HINCKLEY RAIL FREIGHT TERMINAL

Comments for deadline 7

CPRE Leicestershire

February 2024

Figure 6: Proposed ANPR Camera Locations

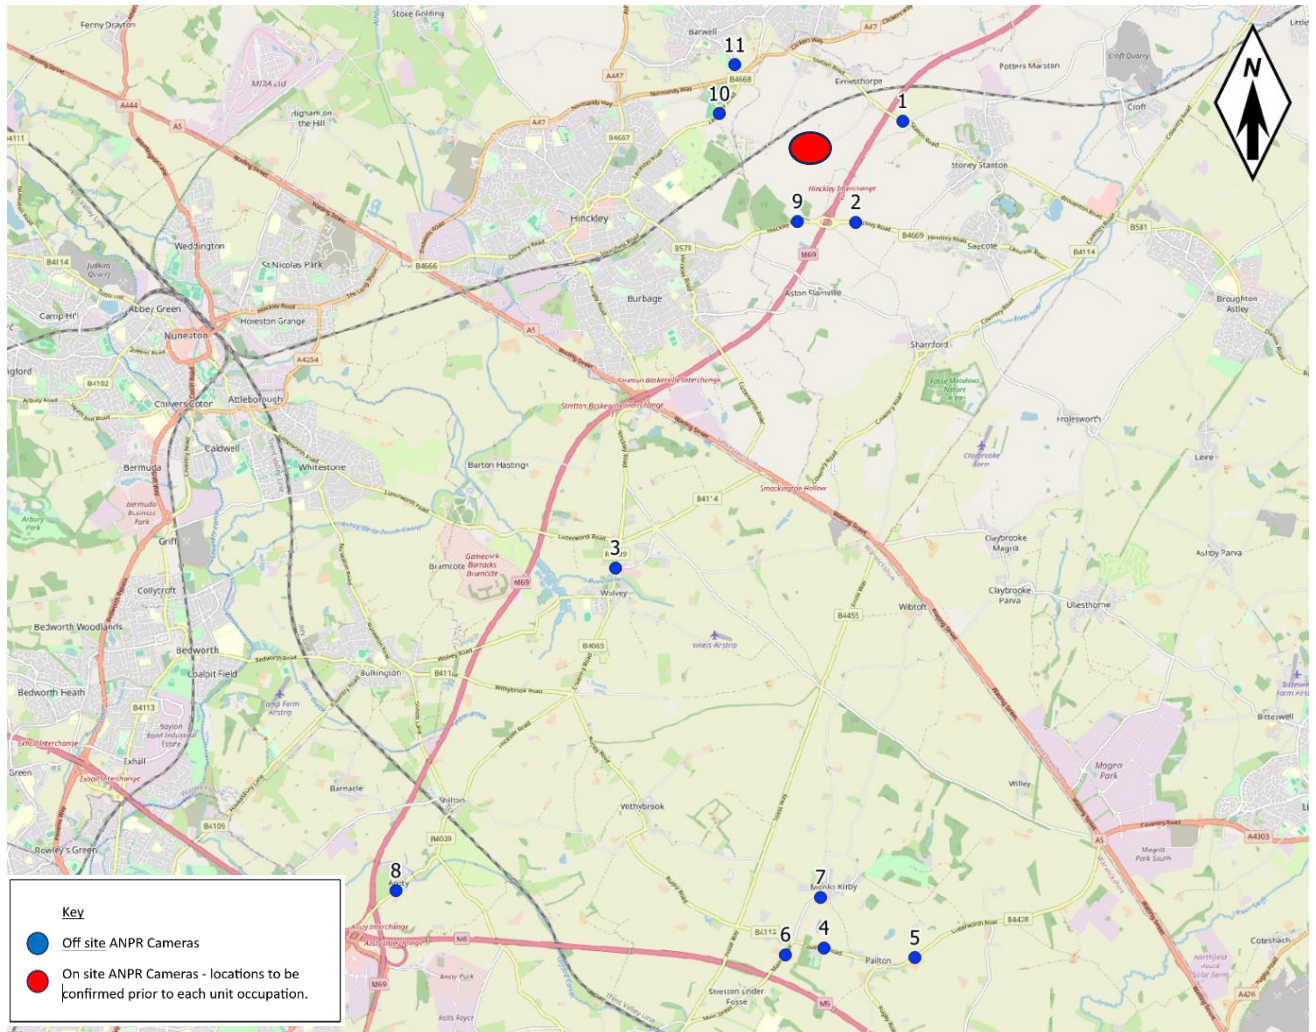
2.16 Note: We welcome the addition of the New RMS Figure 6: '*Proposed ANPR Camera Locations*' which identifies (as requested by the Panel) the locations of the cameras. It underlines our comments at Deadline 6 (para 2.5-2.6) that only camera 2 can measure HGVs going towards Sapcote and its location may allow for debate about their onward route.
